Appendix A – Response to Submissions Table

1.1 The Departments of Planning, Housing and Infrastructure

Figure 17. Prescribed impacts identified within the Subject Land.

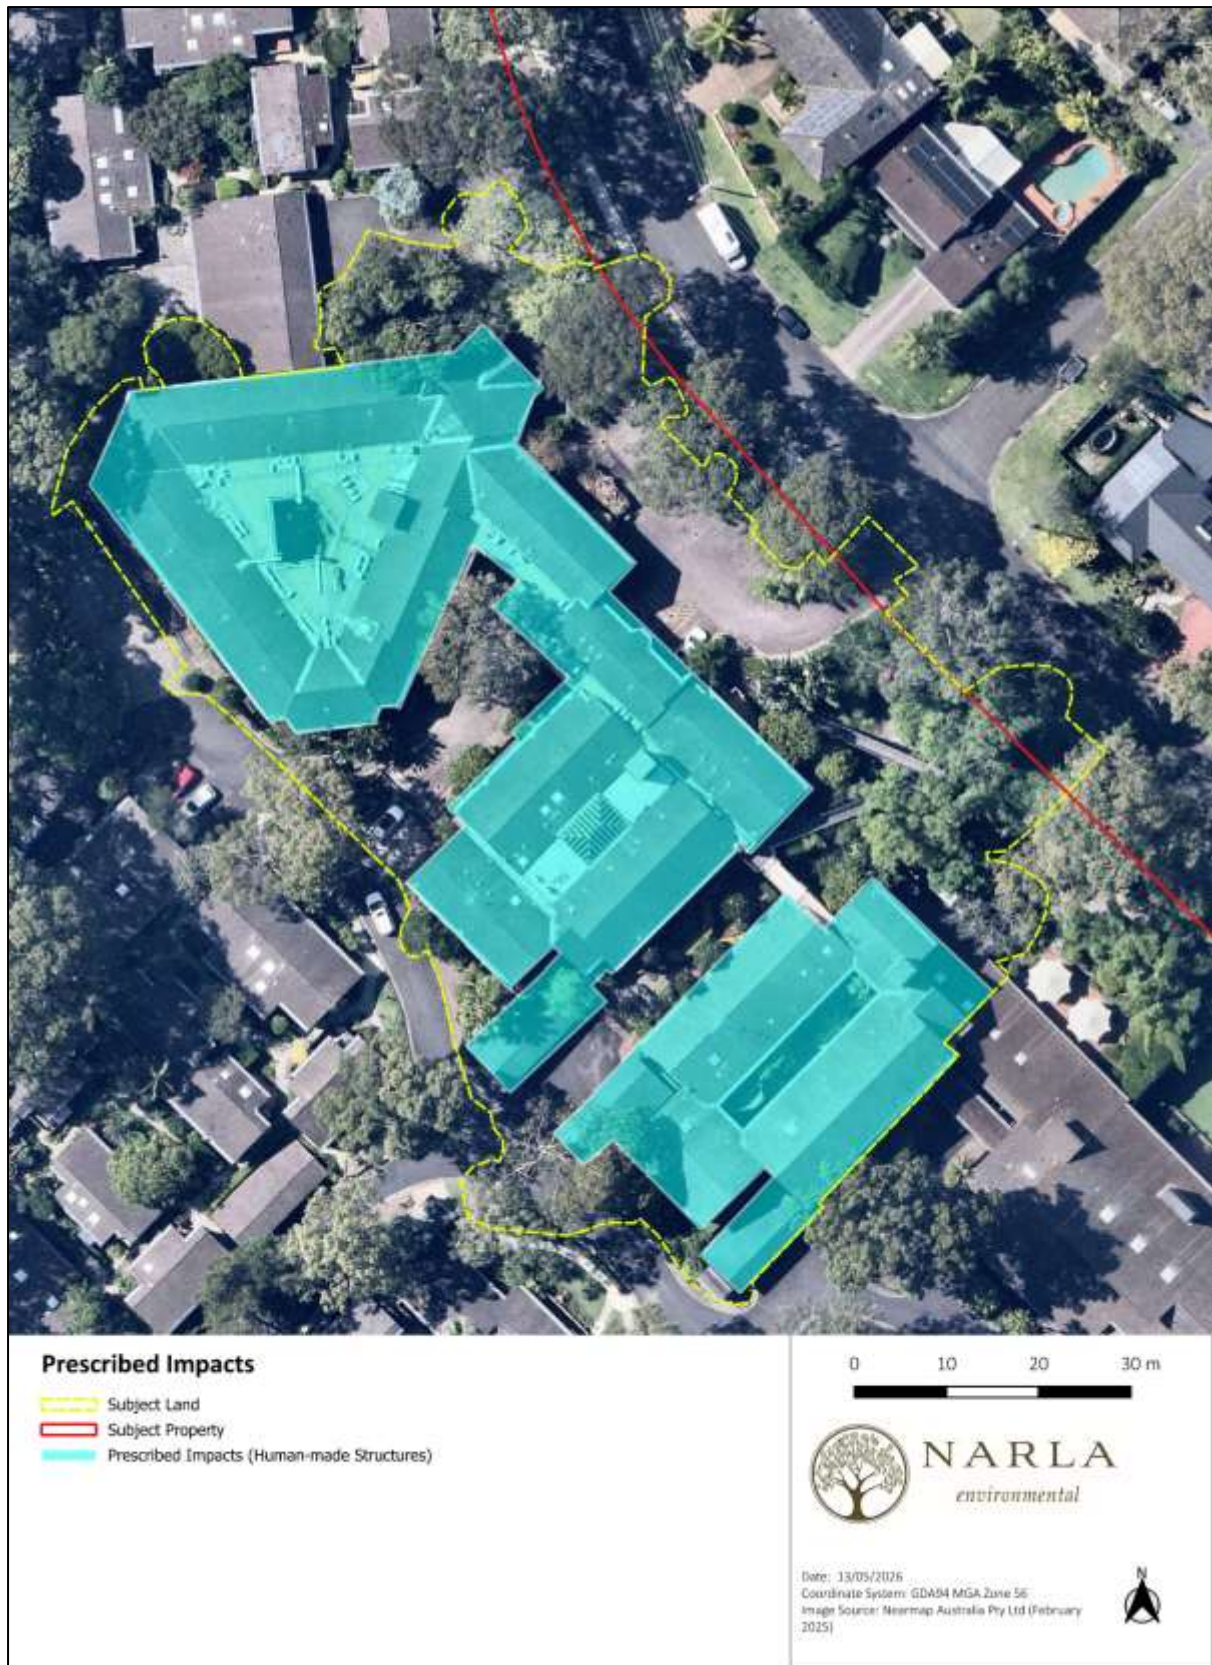
3. Clarify the extent of the impact area The full extent of the development impact footprint requires clarification. Figure 17 of the BDAR shows partial impacts to trees along the southwestern and southeastern boundary. However, aside from Tree 79, the stems of the native trees associated with PCT 3234 occur across the existing internal road and do not appear to be proposed for removal. Neither the AIA or BDAR indicate if these trees will be subject to pruning and ongoing maintenance.	The Amended Streamlined BDAR (Appendix L) and Amended AIA (Appendix M) have been updated to clarify the development impact footprint. The AIA confirms that the native boundary trees are not proposed for removal, except where specifically identified. Tree 79 is proposed to be retained, subject to

Issue	Response/Action
<u>Recommended Actions (pre-determination):</u> Update the AIA or BDAR to clarify if these native trees will be subject to impacts. If these trees are proposed for removal, amend the BDAR mapping and BAM-C accordingly.	arboricultural protection measures and tree-sensitive construction techniques. The BDAR impact mapping has been updated to align with the AIA and to conservatively capture potential canopy impacts associated with retained native trees. No additional native tree removals are proposed beyond those identified in the AIA, and the BAM-C has been updated accordingly where required.
